Comments on Planning Application 2020/60/93867/E

21 Vicarage Meadow
Mirfield
WF14 9JL

Prepared on: 25th February 2021

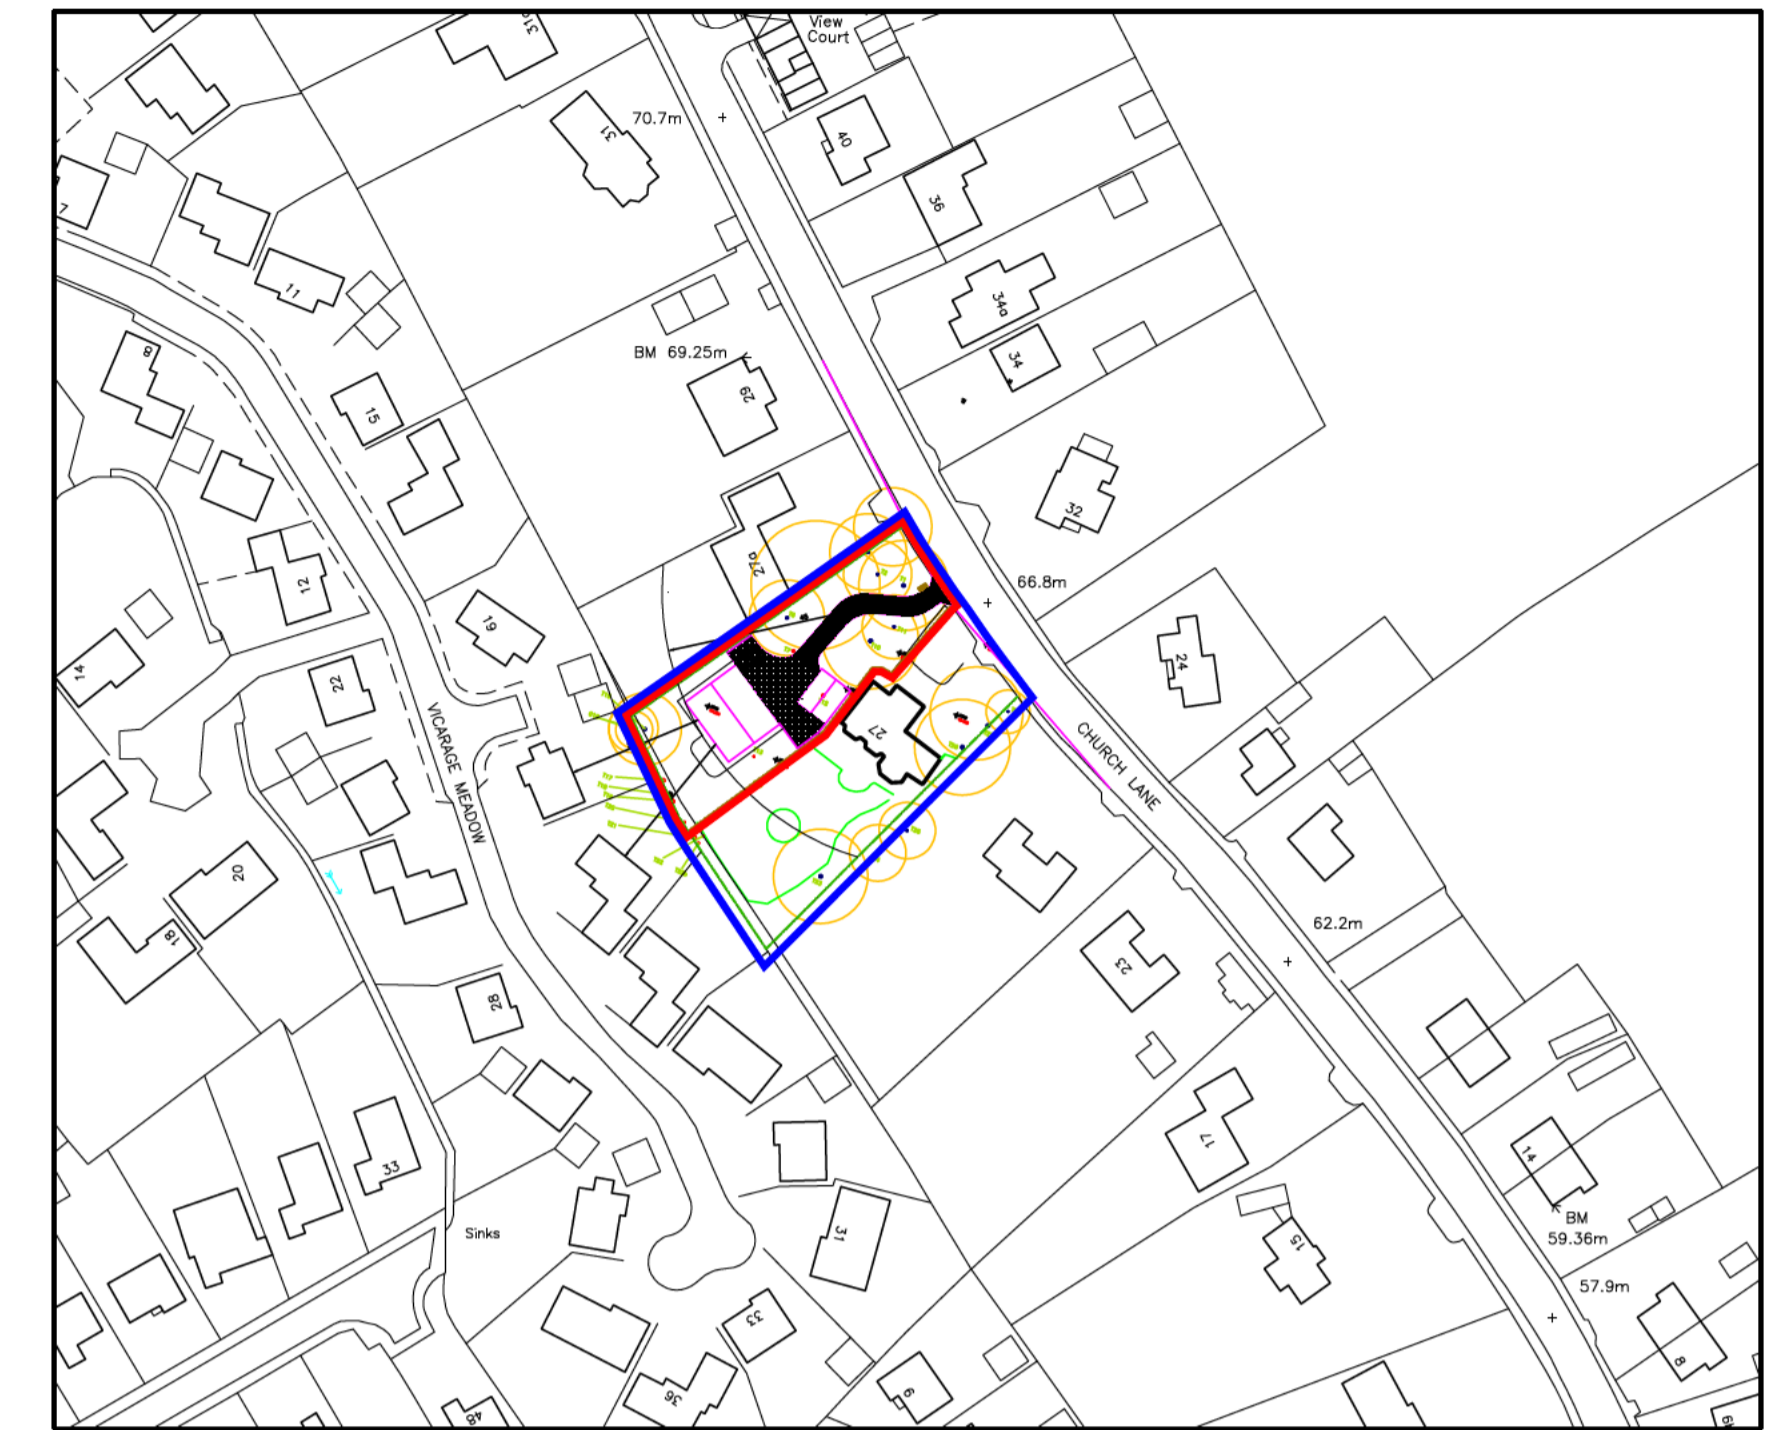
We would draw your attention to the fact that the block plan, submitted in connection with the application, is inaccurate. It fails to take into account the existing extension at the rear of our home. Hence the provided dimension of 22.4 metres is incorrect. The distance between the proposed siting and our own home would be around 20% less than that indicated. This is a material error. Given this misrepresentation we would not automatically accept all other aspects of the drawing are correct.
